Application number: 2024/90923	
What is the application for?:	Demolition of existing conservatory and erection of single storey side extension
Address of the site or building:	Kelvin Villa, 1, Newsome Street, Dewsbury, WF13 4HE
Postcode:	WF13 4HE

Type of comment: An objection	
Do you wish your comments to be published on the website anonymously?	Yes

PROPOSED ROOF PLAN
1:100 @ A1

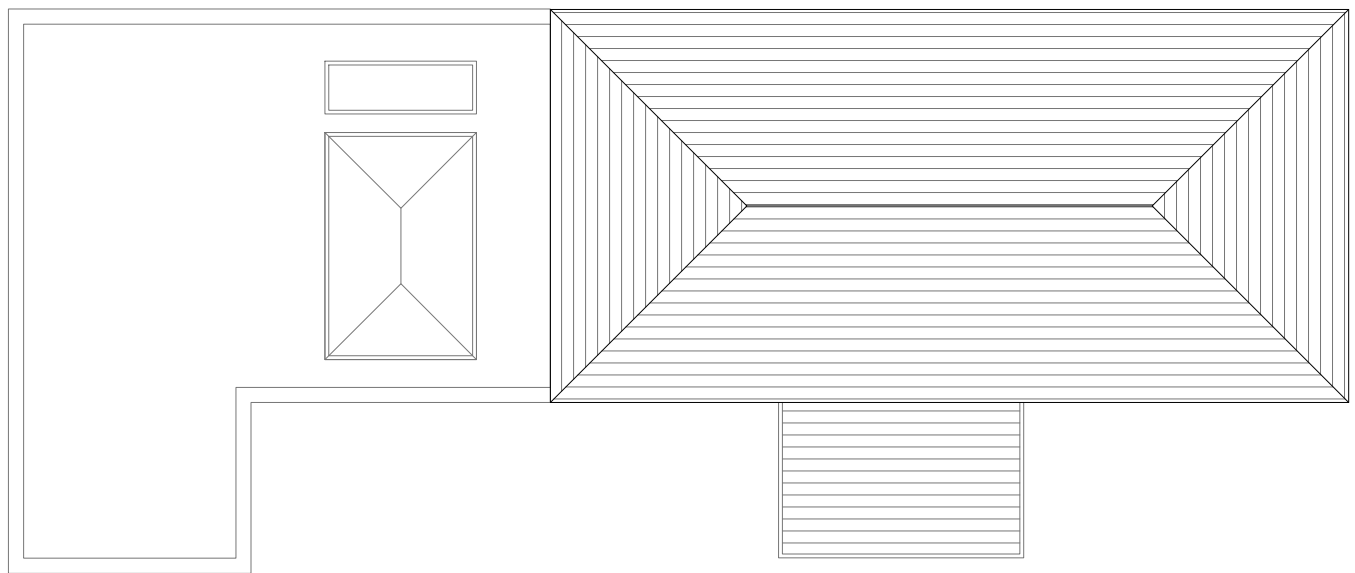
I can 100% confirm there has never been a flat roof as proposed in the new application.

PROPOSED FRONT ELEVATION
1:100 @ A1

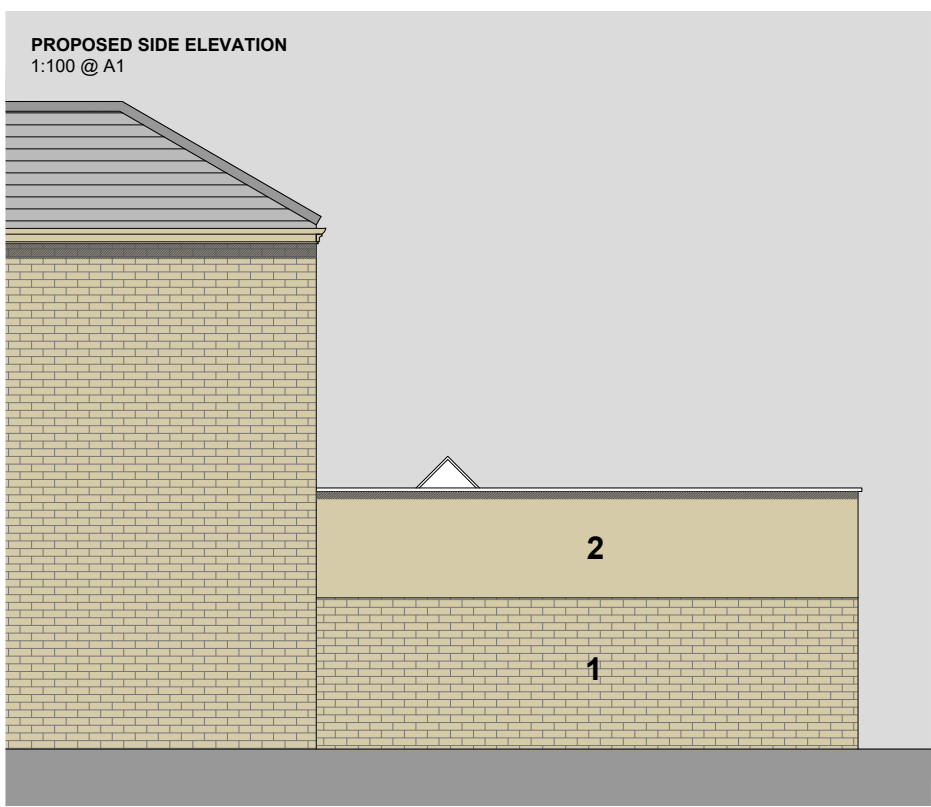
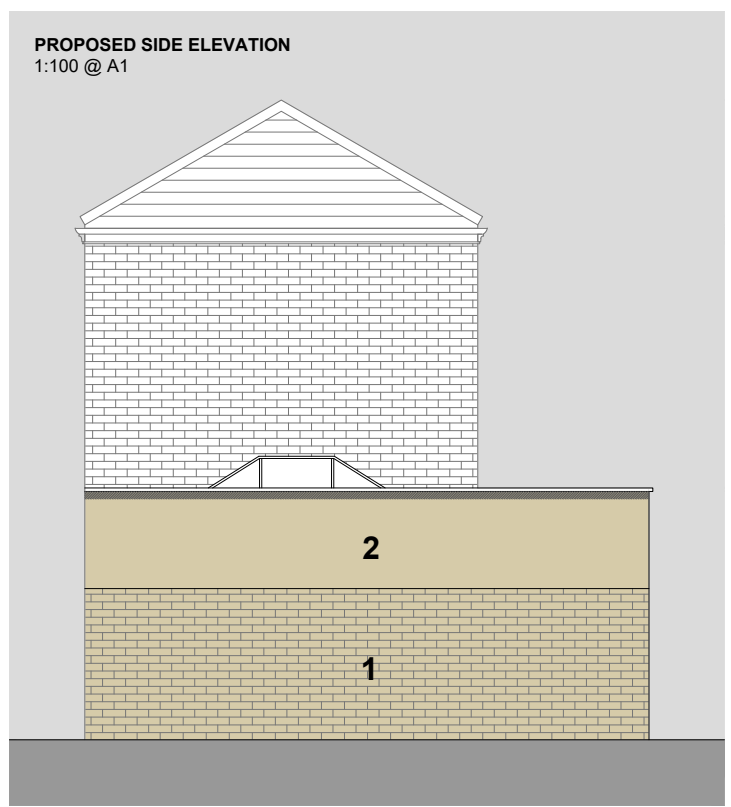
I can 100% confirm the height is too high even on the new proposed planning application.

The new proposed extension comes out too much at the front which takes it past the current property. So will make it look too bulky and a right eyesore with the height being too high.

Before any planning permission is passed the height has to be much lower, front elevation has to be in line with the current house, no flat roof, materials all round must match the current property and no rendering must be used.
